Re. Cadia East – MOD 14 report for comment (MP06_0295-Mod-14)

I refer to your request of 14 January 2021 for advice regarding the Cadia East Project's Modification 14 application and report. The Resources Regulator has reviewed the request.

Figure 5 | Proposed NTSF repair (Source: Modification Report (MOD 14) – Cadia East Gold/Copper Project)

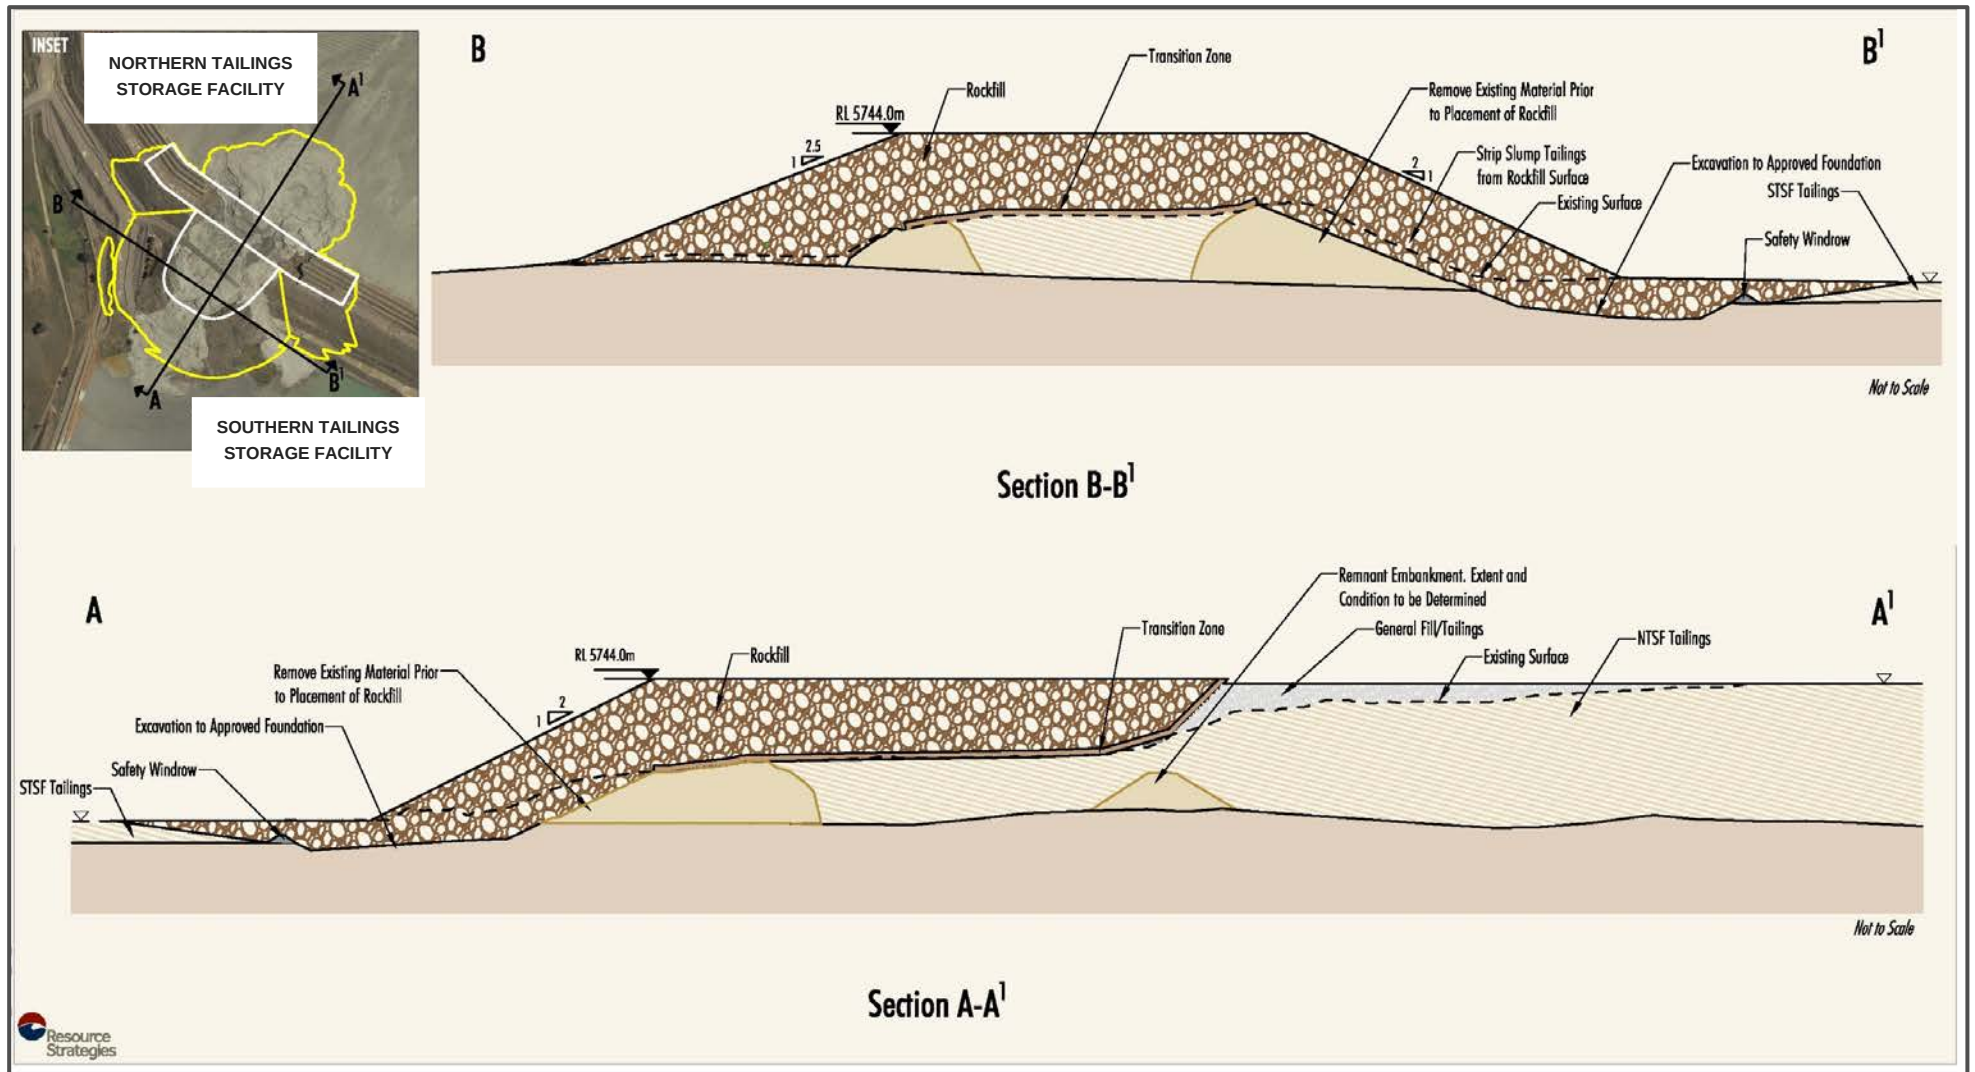
Nomination of rehabilitation objectives specific to the final land use(s)	The rehabilitation objectives are to include a reference to the need to achieve long-term stability of the tailings facility in accordance with requirement specified by ANCOLD. Note: ANCOLD Guidelines on Tailings Dams (July 2019) provides design criteria for closure.
Inclusion of a Conceptual Final Landform Design for the TSF	The design plan should include information on all final landform surface water management structures (including drainages and spillways) and location of final land uses. Clarification is required in this plan for how the final landform will accommodate surface water management in the proposed embankment extension adjacent to the title boundary in the south.
Post-mining landuse	Further information is required to clarify how the final landform will be capable of sustaining the final land use of occasional/opportunistic and controlled grazing. Issues to consider include long term stability, exposure of tailings material and ability to sustain plant growth.

Rehabilitation methodology	Information on the rehabilitation methodology of the Tailings Storage Facility is required. This information is to include information on the final capping design. The source of the material for the cap is also required to

be nominated, to ensure the development consent covers the sourcing, transport and use of this material.
--	--
